**TOWN PLANNING SUBMISSION LETTER – MP 08_0238 MOD 7 – PROPOSED
MODIFICATION OF A COMMERCIAL BUILDING AT 77-81 BERRY STREET (1 DENISON
STREET), NORTH SYDNEY**

Town Planning Submission Letter

4.10 EXISTING STEPPED ENVELOPE
The DA Approved envelope had a stepped form that facilitated an improved outlook and skyplane for the residents of the adjoining tower

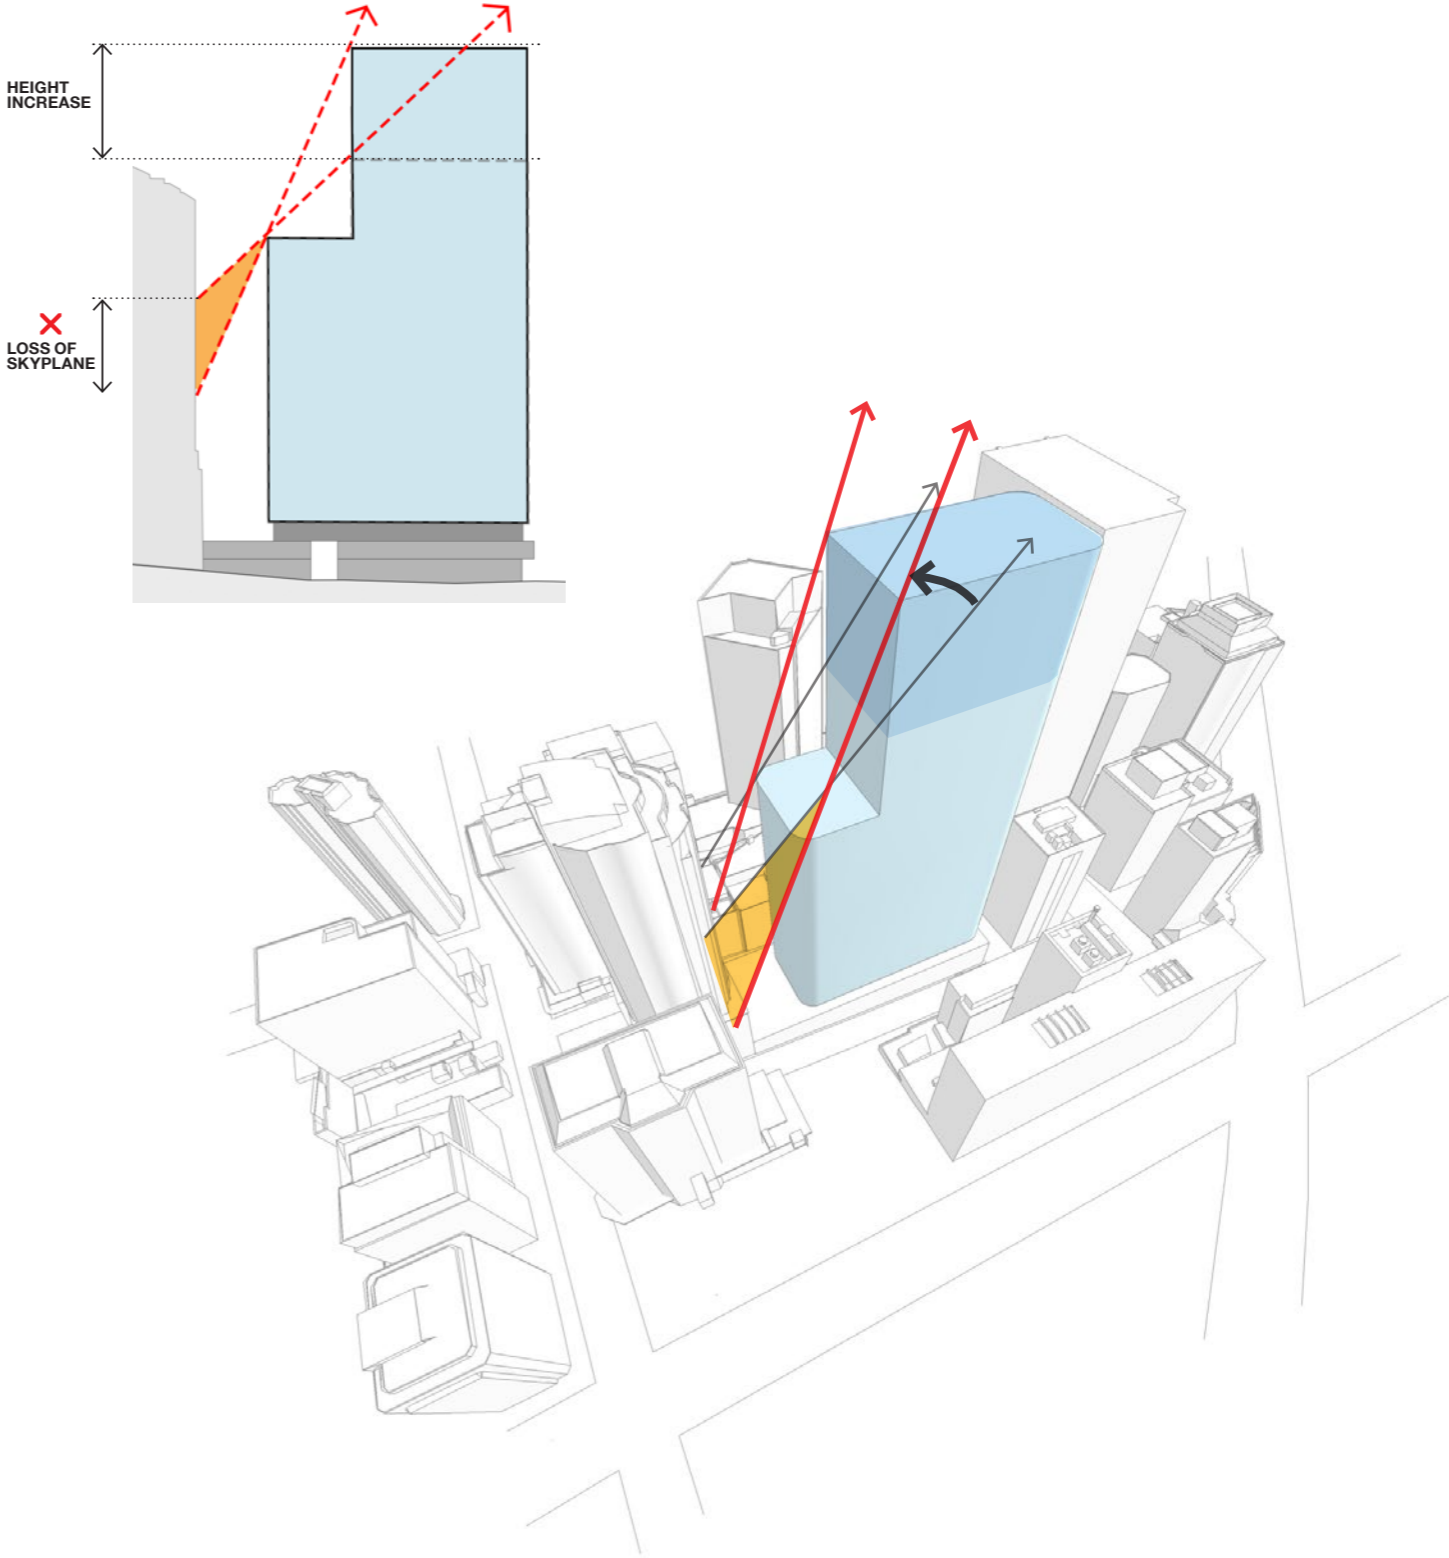
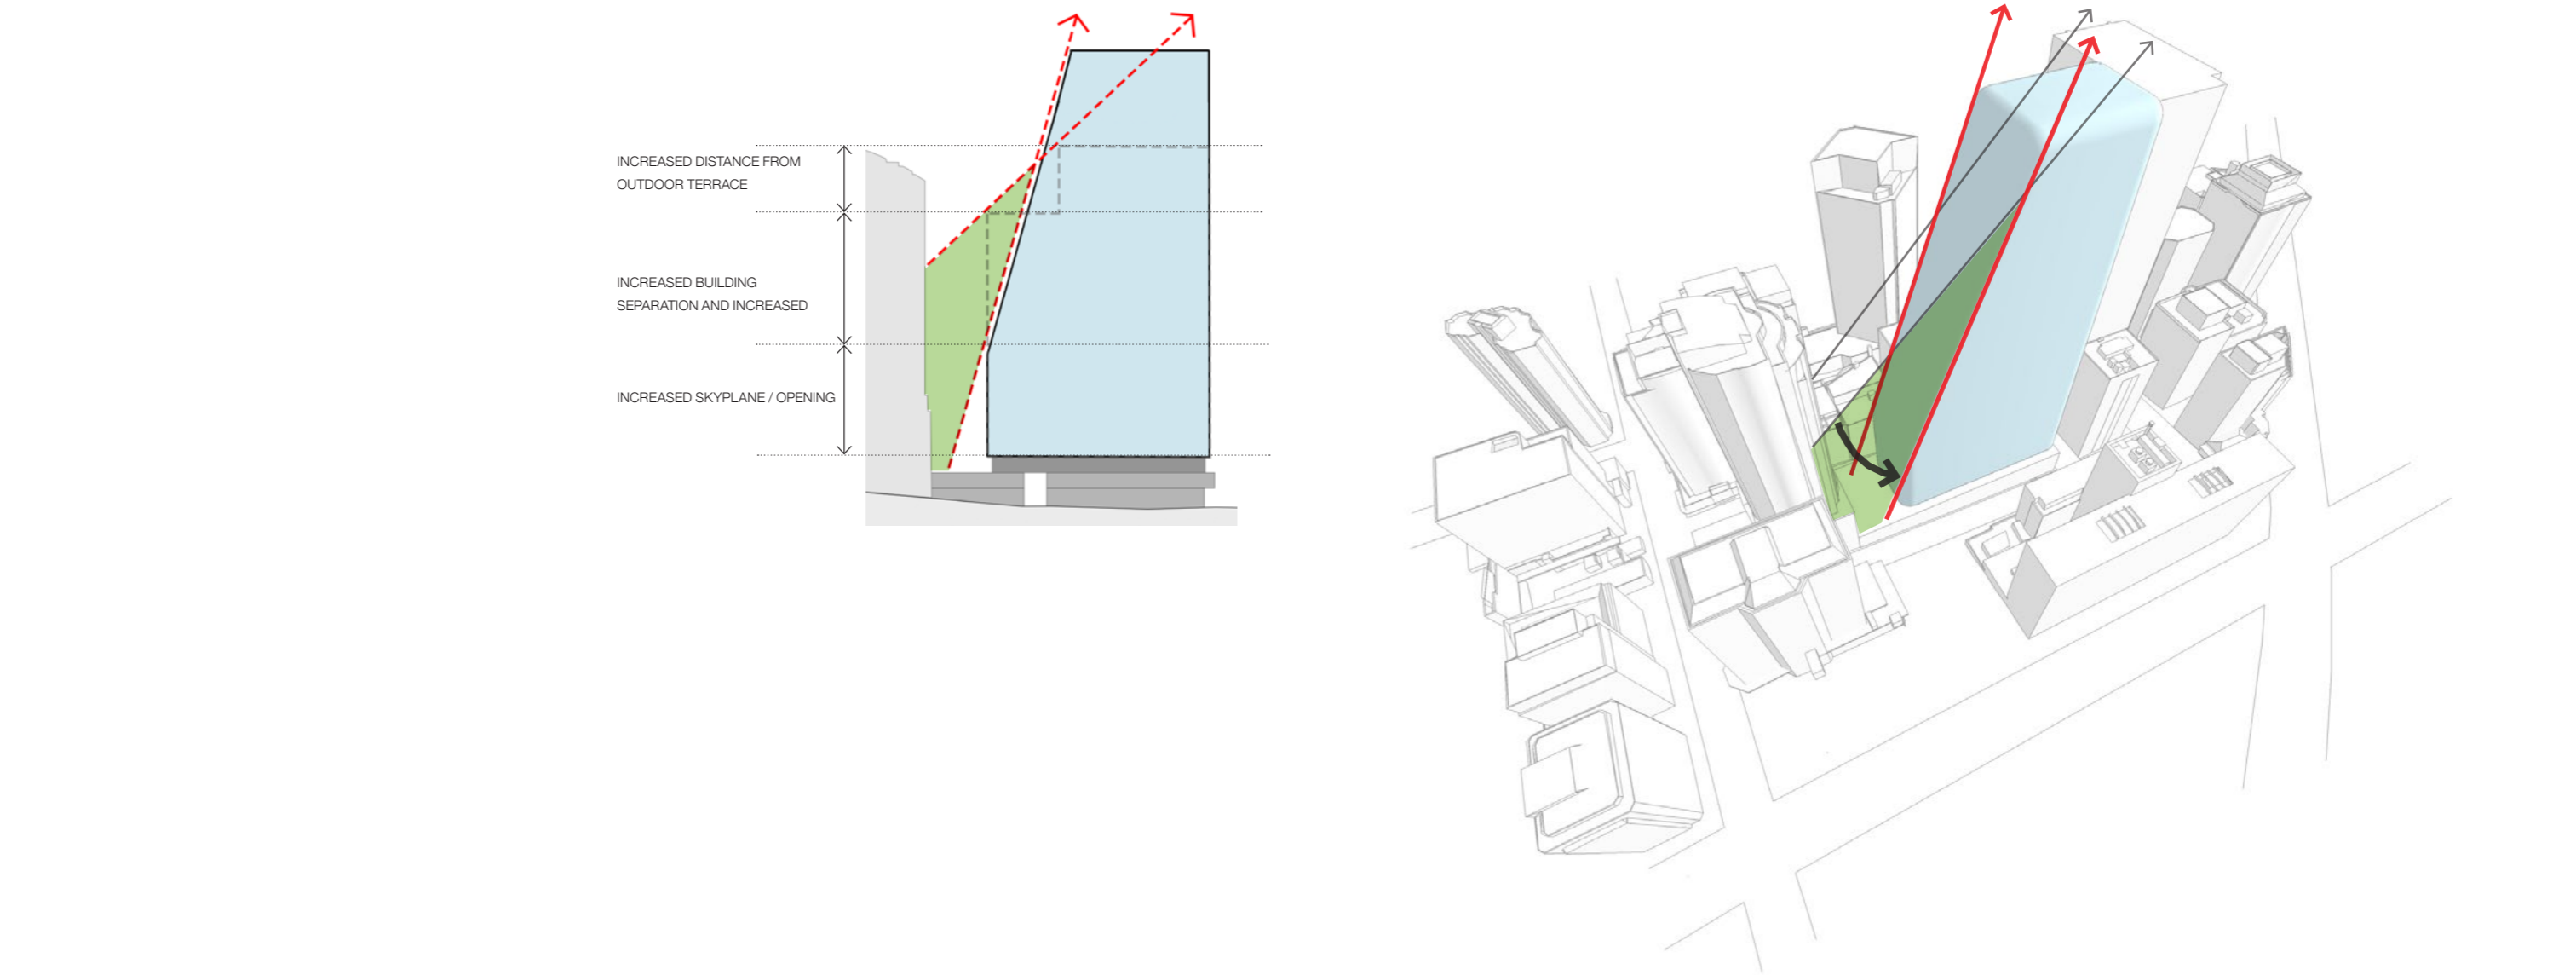
So as not to further compromise view sharing, particularly in light of view loss already being devastating as a result of the approved development, it is recommended that no additional building height is approved. Additionally an opportunity is identified in tapering the building form to provide a slimmer tower and therefore further reduced view loss.

is recommended that the tapered building form is again revised to provide a slimmer tower with no lesser building separation for any levels than previously approved.

The proposed development exhibits greater building height, bulk and scale than the approved building on the site. In particular reduced building separation is provided to the north at upper levels resulting in the encroachment of the building at these levels by up to 9m beyond that previously approved. Also the provision of seven (7) additional storeys above what could already have been described an 'oversized development' adds significantly to the scale of the building.
